CITY OF PORTLAND BUILDING PERMIT

Located At 175 BEACH RD

Job ID: 2011-11-2595-DRG

has permission to Build shed 16' x 24' Cliff Island

SECTION
NTS

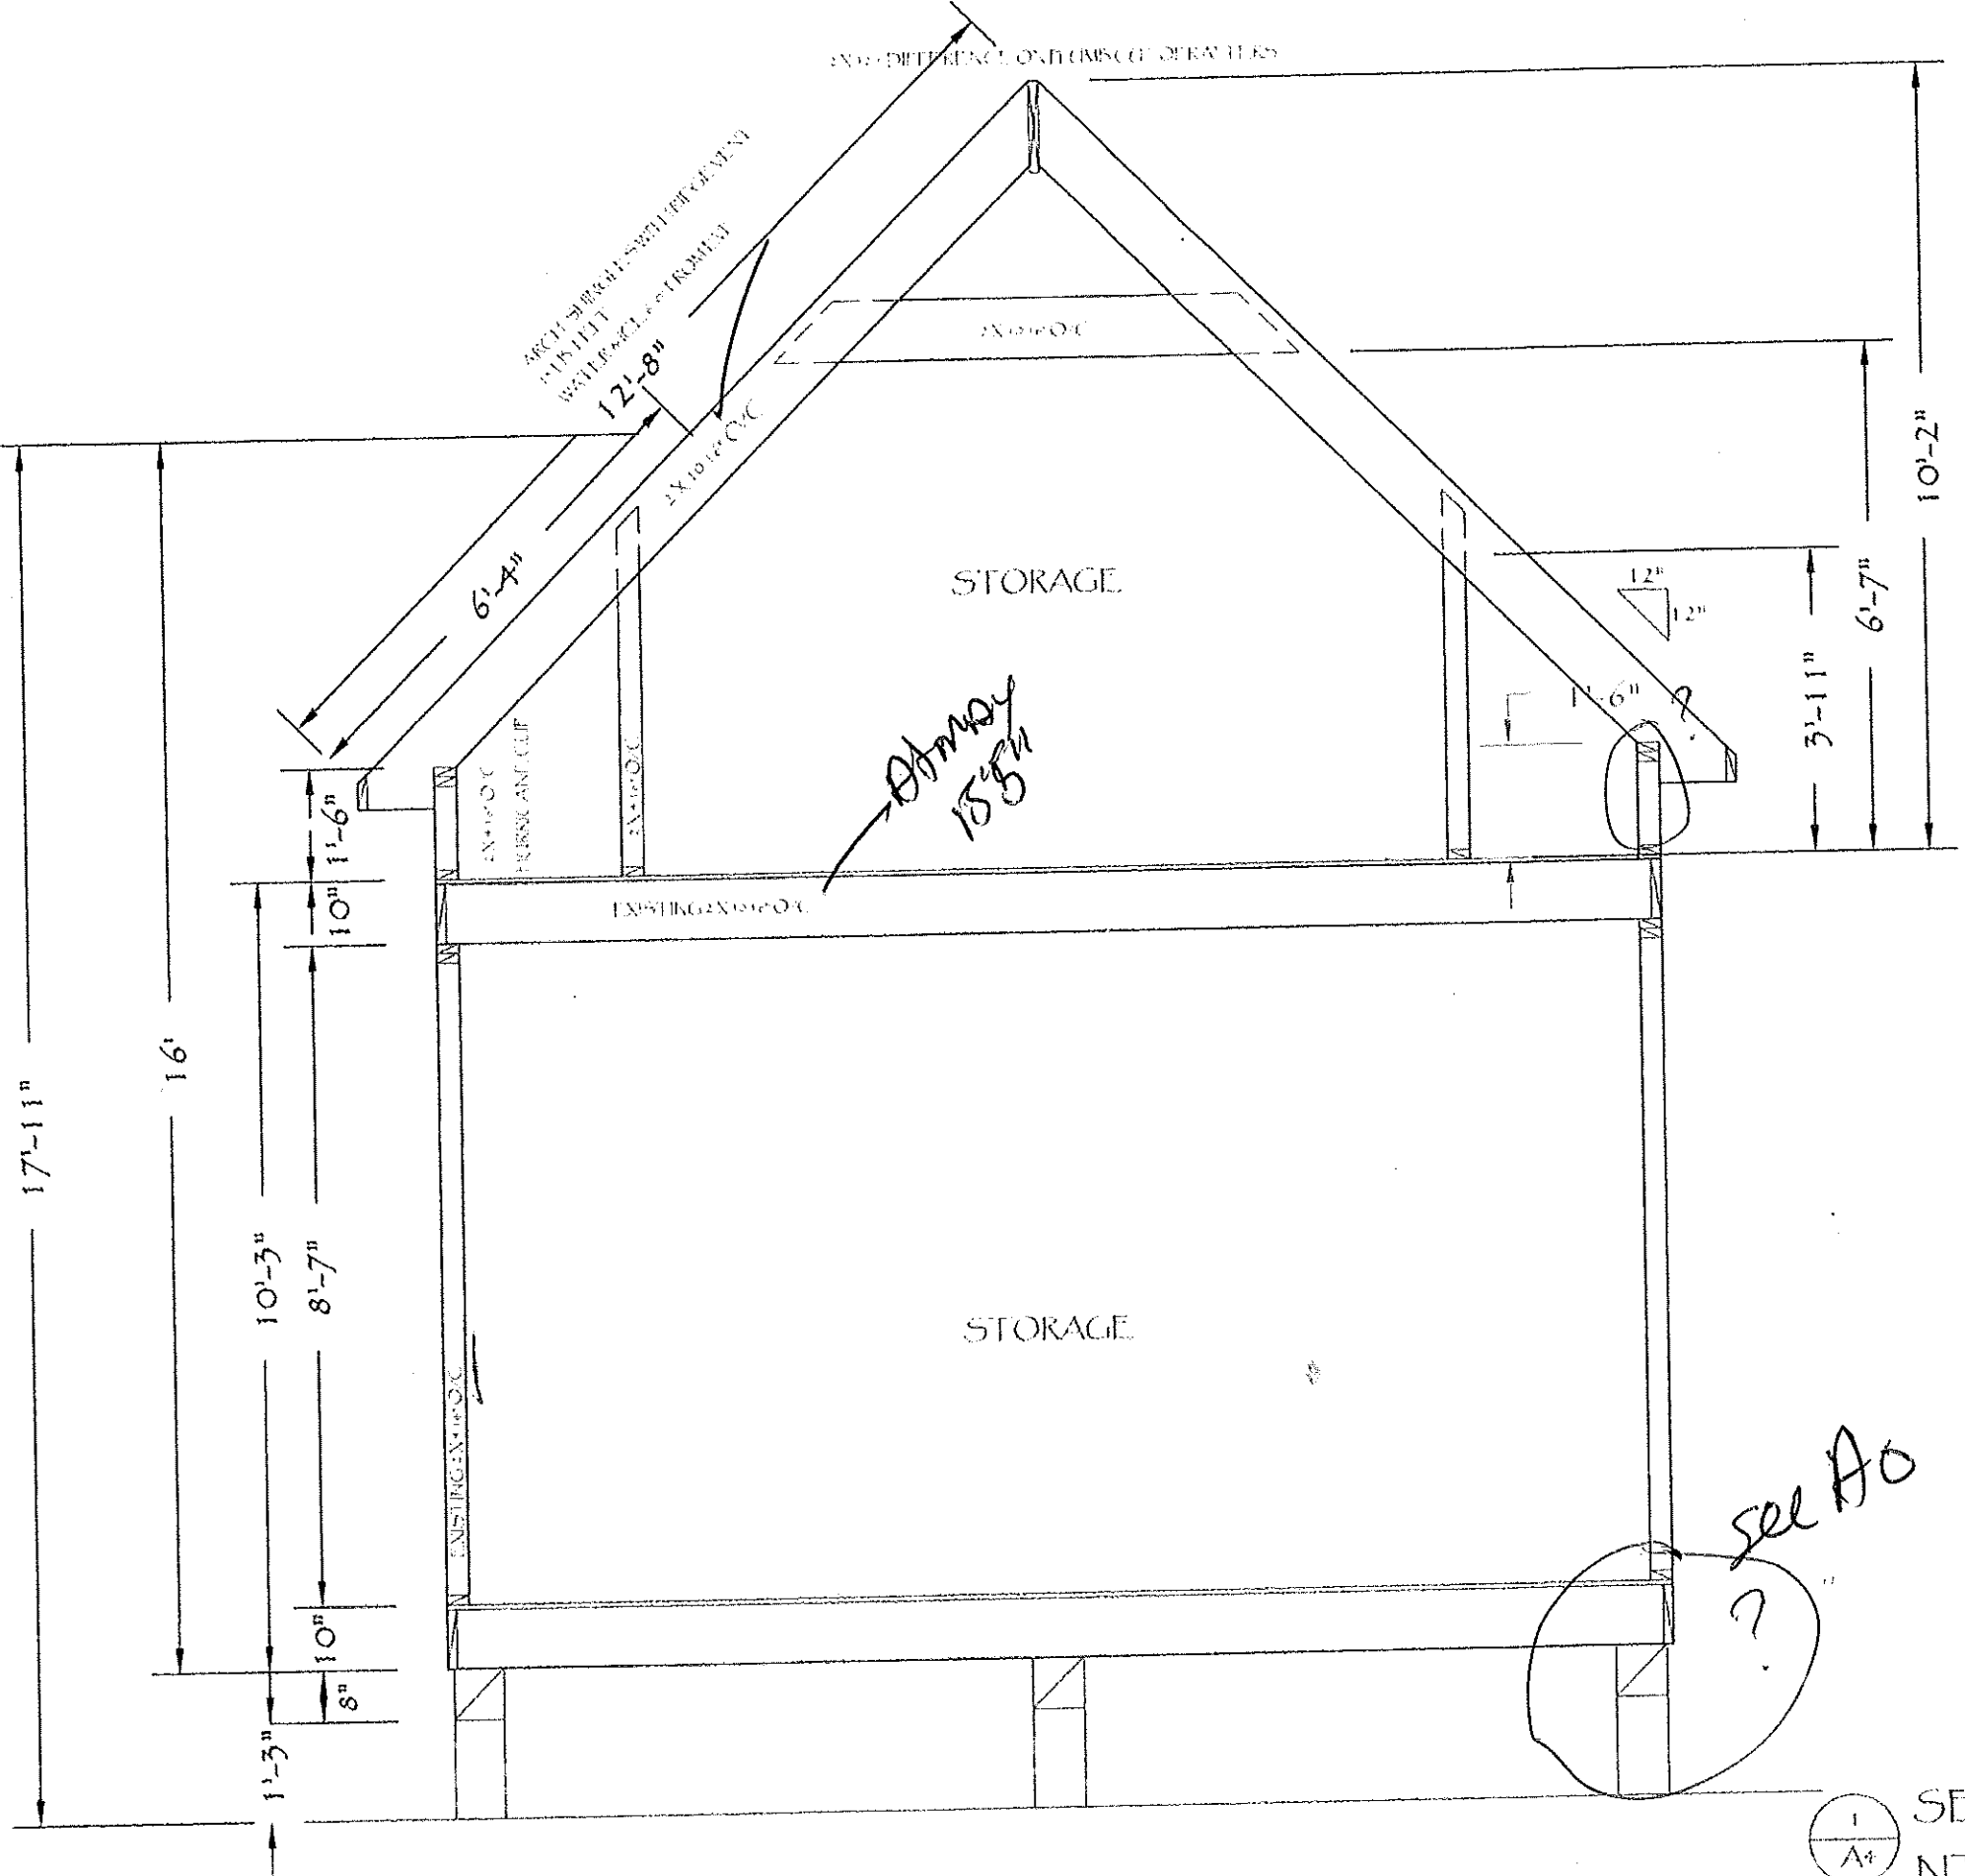
7. AS per conversation with George Trojan (Contractor) this permit is approved with the above conditions however; a new framing plan shall be submitted to this office before close-in inspection. The city will approve either a structural ridge with the 1'6" knee wall or plan approved with no knee walls with rafters resting directly on the floor.
